**Laurie Leader - Re: BP#2015-03002 114 Emery Street**

**From:** Kathryn Buxton <buxtoncomm@gmail.com>  
**To:** Laurie Leader <LRL@portlandmaine.gov>  
**Date:** 2/26/2016 12:01 PM  
**Subject:** Re: BP#2015-03002 114 Emery Street  
**CC:** Rick Ackermann <rickpackermann@gmail.com>, <jmuldoon44@gmail.com>

ACKERMAN CARRIAGE HOUSE  
WEST ELEVATION  
(CUTS)

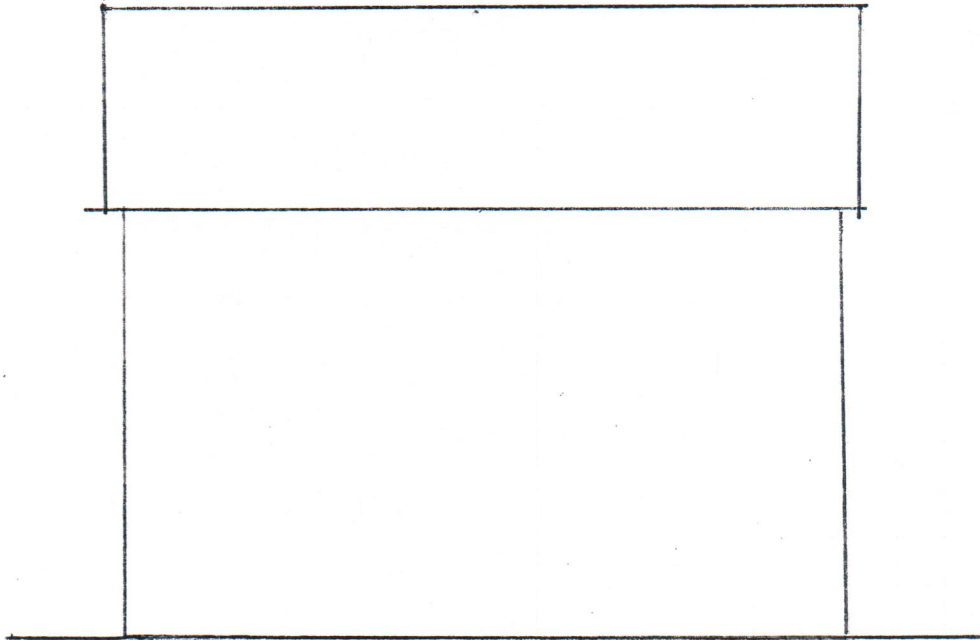
1. Are the existing clapboards being completely removed and replaced with Hardi-Plank cement clapboards? If so, clarify if the 5/8" GWB being installed on both side of the existing walls? (See Table R302.1 Exterior Walls.)
2. Are you replacing the window adjacent to the existing stairway at the top of the stairs? If so, reference Section R308.4 Hazardous Locations and confirm if tempered glazing is required.
3. See Table 402.1.1 Insulation Requirements in chapter 4 Residential Energy Efficiency. Revise ceiling insulation value to meet code (we are in zone 6).

- We will be removing the existing siding and using 5/8" GWB on both the interior and exterior of the two walls that sit near the property line, in addition to the Hardi-Plank siding.
- We are replacing the window at the stairwell and that window will use tempered glazing.
- The ceiling on the second floor will have an attic space, so the R38 should meet code (402.2.1 Ceilings with attic spaces).
